Norfolk Vanguard Offshore Wind Farm

The Examining Authority's Rule 17 requests for further information or written comments

Issued on 21 May 2019

CAWSTON HIGH STREET - INTERVENTION SCHEME
Scale 1:500

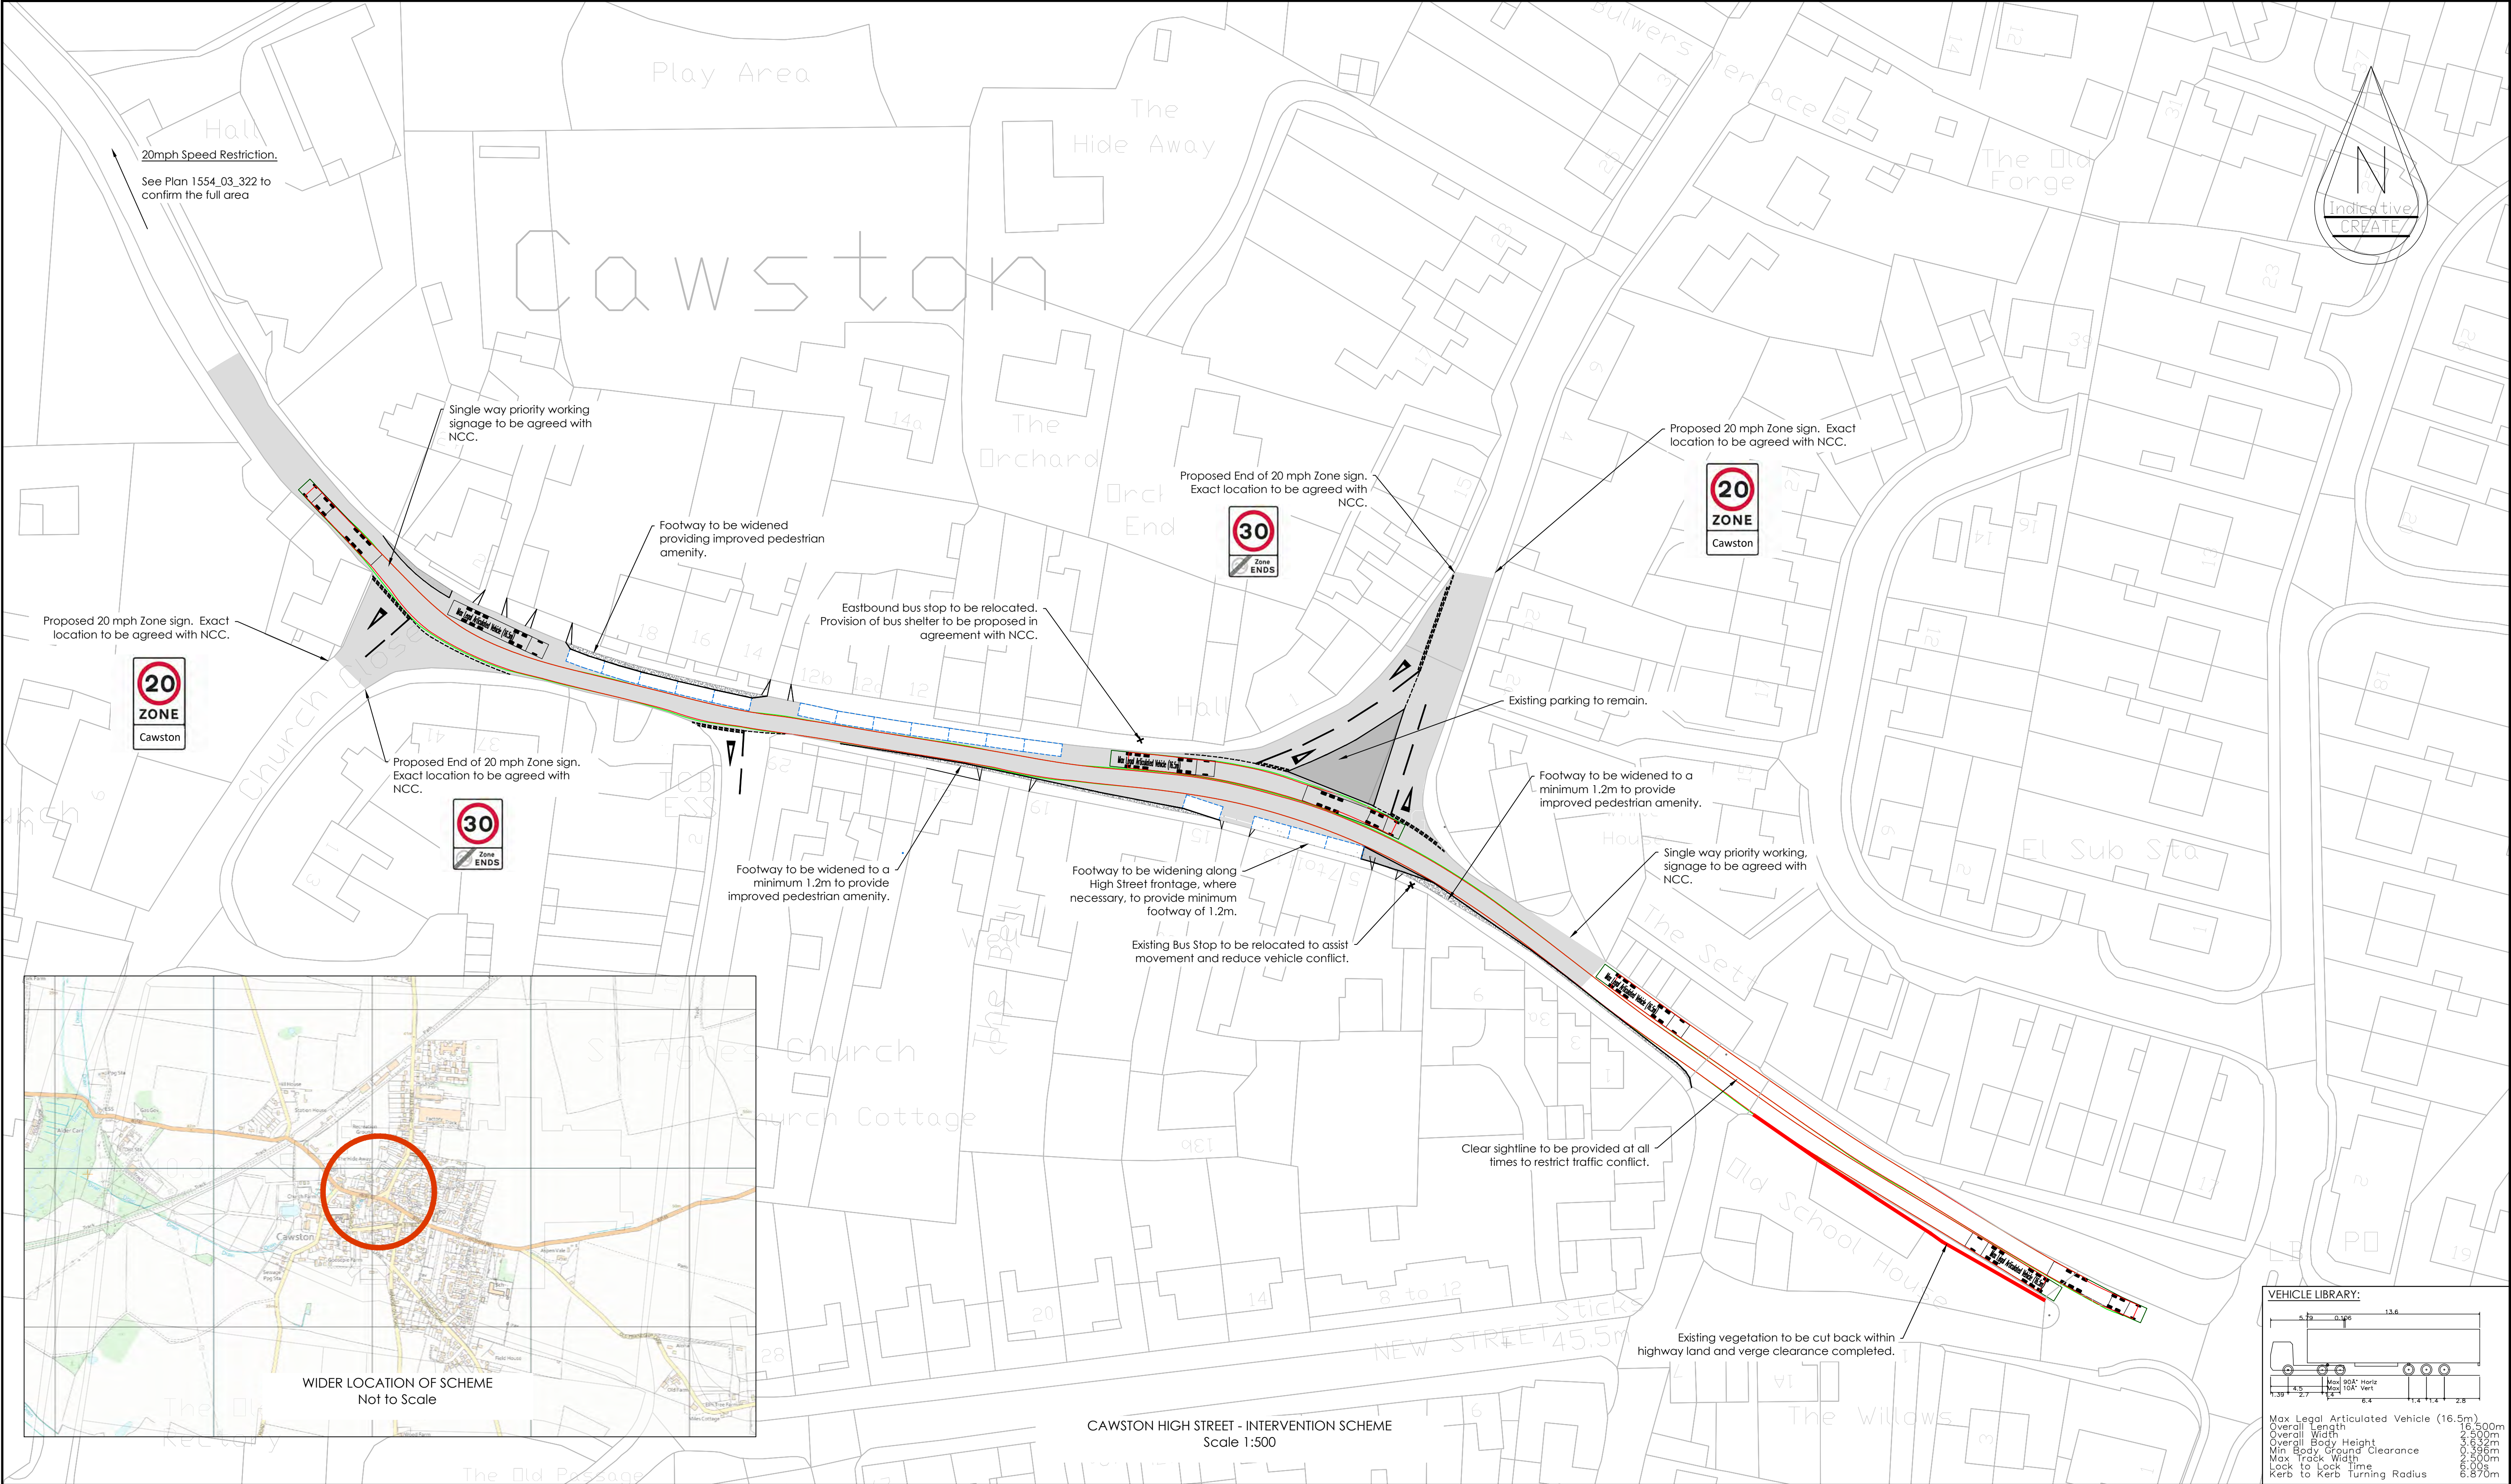
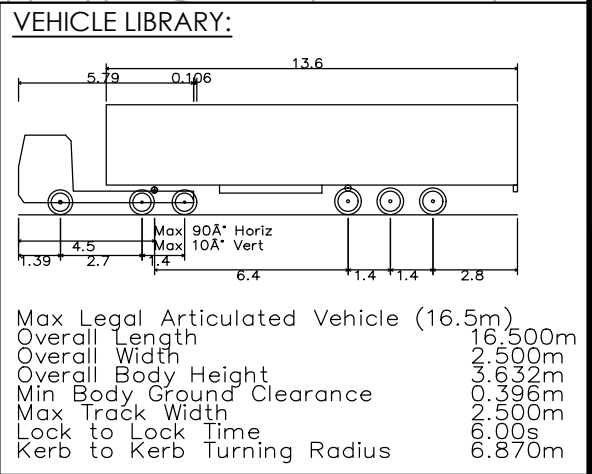
FQ 5.5	Applicant/Norfolk County Council	<p>The H3 Highway Intervention Scheme dated March 2019 is still under consideration and it provides an illustration of some of the mitigation measures which could be utilised. This scheme retains some demarcated on-street parking which would result in HGVs having to wait in turn based upon 'single way priority working signage'. Having regard to the traffic</p>

Request made to:		Information or written comments requested:
		<p>movement figures above, namely one HGV every 2 minutes, how is it envisaged that such a scheme would work and be effective?</p> <p>In particular, how long would one HGV take to navigate the route through Cawston village. How long would the wait times be for HGVs travelling in the opposite direction?</p>
FQ 5.6	Highways England	<p>In light of the traffic speeds and volumes of traffic along the A47, please confirm the basis upon which you are prepared to accept a relaxation of DMRB standards in the visibility splay requirements in relation to access B in regard to vehicles exiting the site and turning right.</p>
